SUNNICA ENERGY FARM

EN010106

8.103 Environmental Mitigation Parcel Schedules

Version	Date	Status of Version
Rev 00	3 March 2023	Deadline 7 Submission

Drawing Title
**ENVIRONMENTAL MASTERPLAN
 DETAILED PLANS
 SHEET 4
 EAST SITE A**

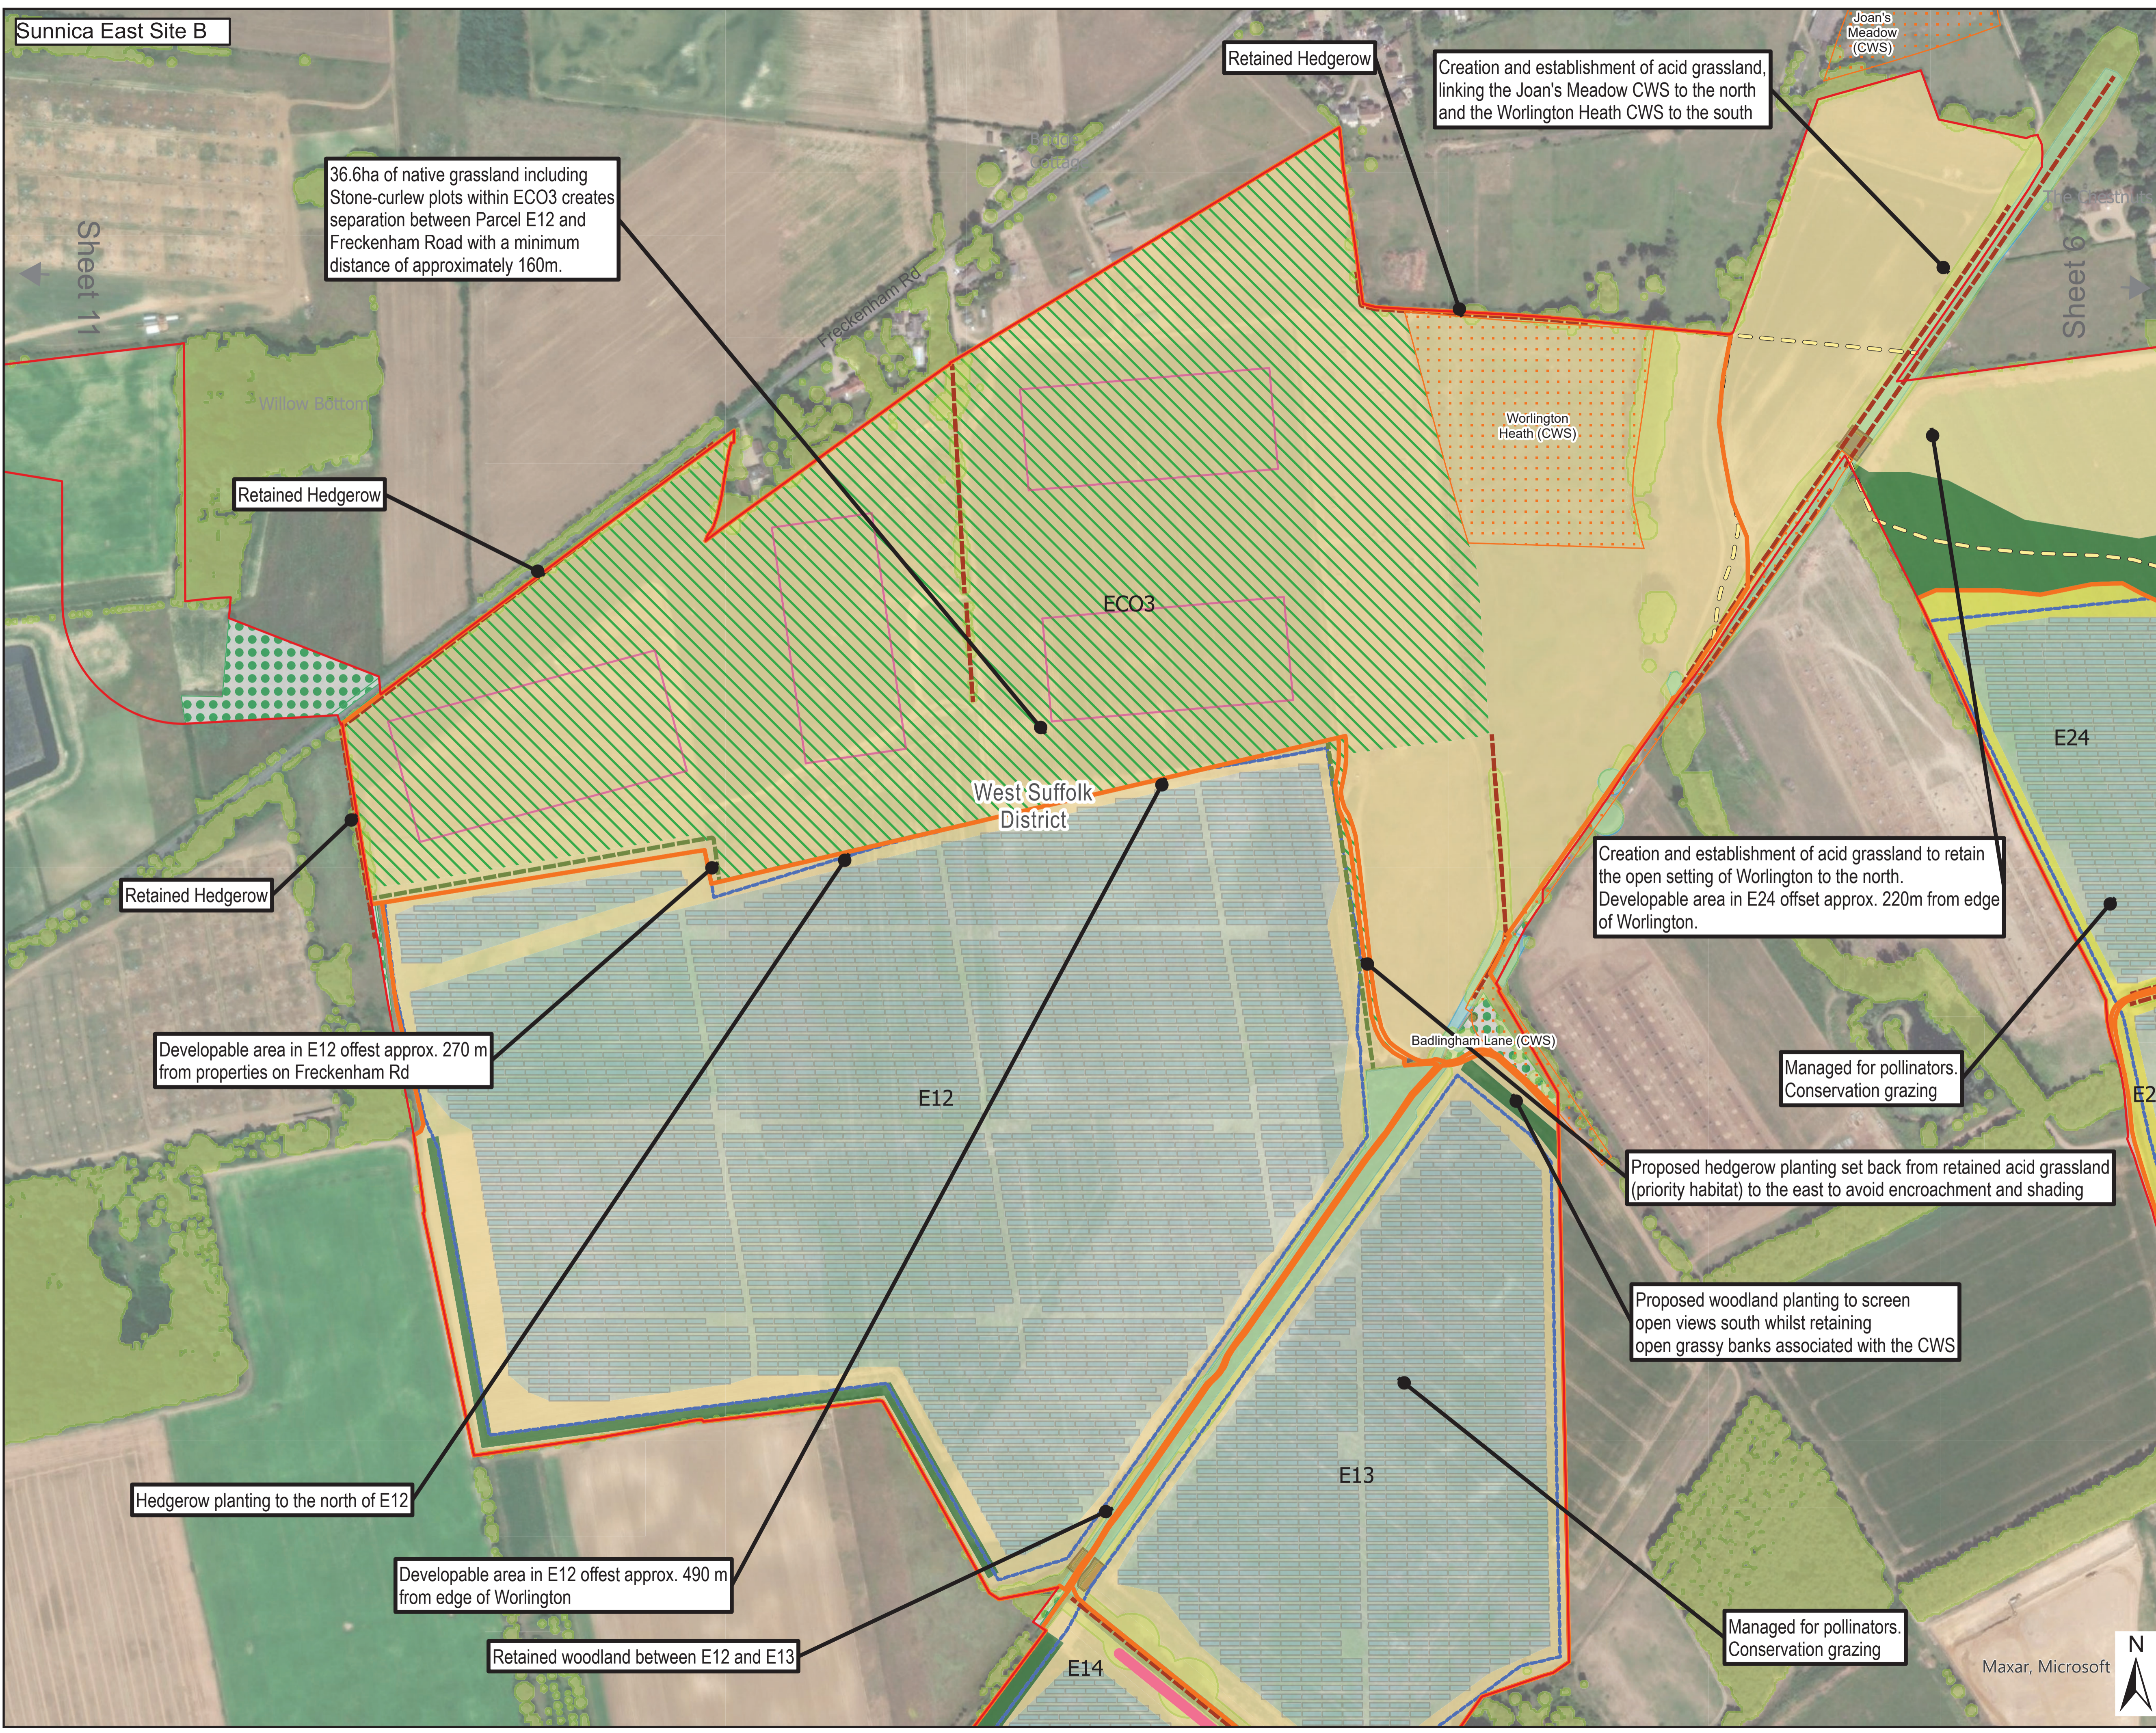
E09	Sunnica East Site A, Sheet 4	The western boundary of E09 will be defined by a 15m wide belt of trees and shrubs, parallel with the avenue lined track into Lee Farm	For E09 and E10 the applicant should consider how the second hedge can be adapted to strengthen and enhance the existing hedge on the southern boundary	The proposed hedgerow north of Beck Road has been changed to a band of mixed shrubs, 10m wide, adjacent to the existing hedgerow,

Sheet 5

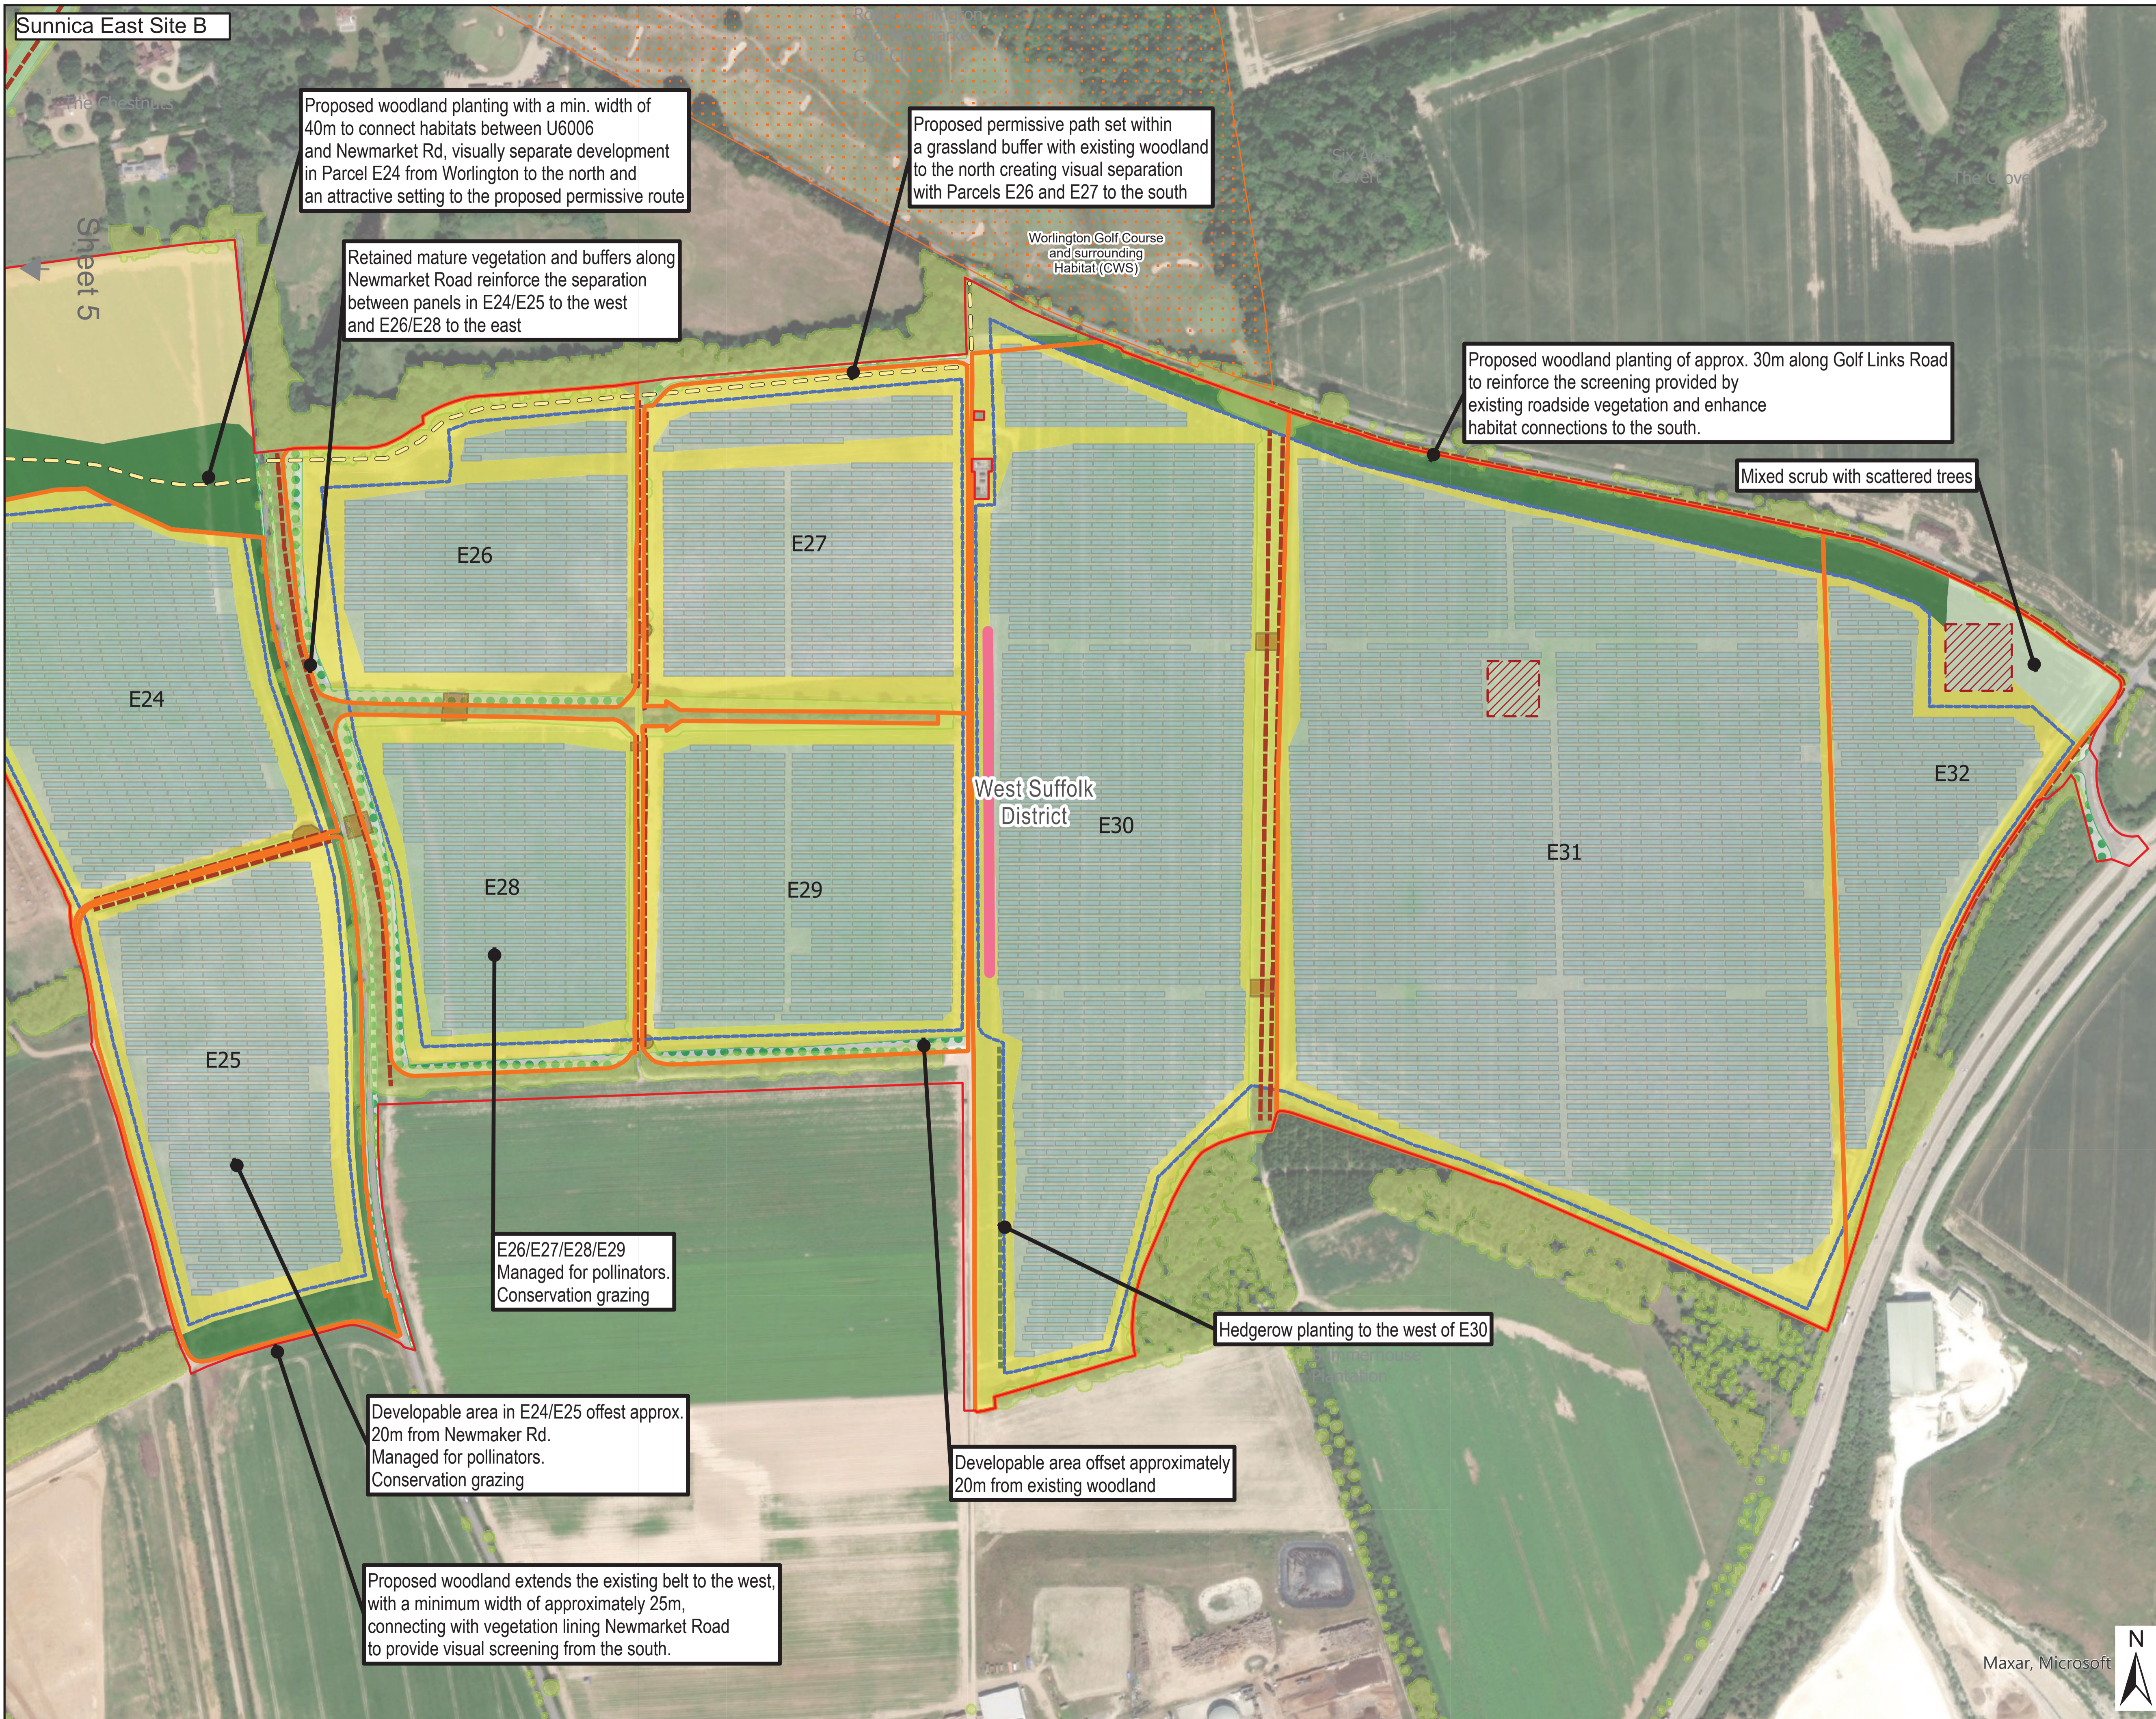
Parcel Number	D7 Environmental Masterplan Sheet Number	Summary of Measures Proposed	LPA Position	Applicant Response
E12	Sunnica East Site B, Sheet 5	<p>The southern boundary is defined by a well-established pine line, which forms a clear boundary and visual screen. This extends to the west as a hedgerow, which creates enclosure. The northern boundary is proposed to be a native species hedgerow, which at D5 was extended along the eastern boundary to join the pine lines which follow the U6006 and complete the enclosure of the parcel and to reflect and reinforce the wider landscape pattern typical of the Breckland.</p>	<p>The Councils still considers the visual impact on the U6006, the loss of woodland TPO trees (which form a pine line along the southern boundary of E12 with the U6006 (G81 on AIA)), and the visual impact on open landscape when viewed from Worlington and from properties on Freckenham Road to be unacceptable. The Councils therefore still consider that E12 should be removed from the scheme. Failing this...</p> <p>. Provide an appropriate set back from U6006 – the preferred approach is the ‘half-way house’ [REP5-084]</p> <p>There should only be one crossing point across U6006, where vegetation loss is minimal</p> <p>The additional hedgerow along the eastern boundary of E12 would be an improvement in visual amenity for the users of U6006.</p> <p>Provide screen planting along the south-eastern boundary- hedge and pines. (see VP15A).</p>	<p>Applicants position is outlined in its response the LPA Deadline 6 Submissions [EN010106/APP/8.89], which concluded that the loss of the generation capacity from the Scheme that is proposed by the Councils could in no way be reasonably characterised only as a small reduction in function. In addition, it is the Applicant’s position that the removal of the parcels would not result in an exceptional landscape or visual benefit. However, the Applicant has reviewed the design and has incorporated a 30m set back either side of the vegetation which lines this section of U6006 to the security fence. There will be a further 5m offset from the fence before the closest panels, so 35m in total. This will create a wide area of native grassland either side of U6006, further reducing the potential for visual impacts in glimpses through gaps in vegetation and reducing overall perception. The existing vegetation along U6006 in this location will be strengthened through natural regeneration and</p>

Parcel Number	D7 Environmental Masterplan Sheet Number	Summary of Measures Proposed	LPA Position	Applicant Response
				<p>interplanting. This is noted on the Environmental Masterplan and in the OLEMP submitted at D7.</p> <p>The Applicant can confirm that there would only be one crossing point of the U6006 and all electrical cables will be installed using no-intrusive methods, which is secured through the CEMP [EN010106/APP/6.2].</p> <p>A pine line has been incorporated along the eastern boundary of E12.</p>
E13	Sunnica East Site B, Sheet 5	<p>Existing vegetation around the edges of the parcel create enclosure. The pine lines along U6006 enclose the western boundary, joining a pine line on the southern boundary. Woodland lies immediately to the east. A small belt of trees and shrubs is proposed on the northern side to complete the enclosure and screen views into the parcel from U6006.</p>	<p>E13 should be omitted from the scheme for ecological reasons. If this is not possible and being sensitive to the existing landscape structure...</p> <p>Retain curves in U Road between E13 and E14.</p> <p>Provide additional hedge along and adjacent to U Road corridor.</p> <p>Retain all existing vegetation through use of direct drilling.</p> <p>Provide hedge along eastern boundary and along south-western boundary (along northern side of existing track) (see VP15B) of E13, outside the RPA of the veteran trees.</p> <p>Remove panels from the existing area of acid grassland</p>	<p>Applicants position is outlined in its response the LPA Deadline 6 Submissions [EN010106/APP/8.89], which concluded that the loss of the generation capacity from the Scheme that is proposed by the Councils could in no way be reasonably characterised only as a small reduction in function. In addition, it is the Applicant's position that the removal of the parcels would not result in an exceptional landscape or visual benefit. In addition, appropriate ecological mitigation has been incorporated into the design for Stone Curlew which has been agreed with Natural England.</p>
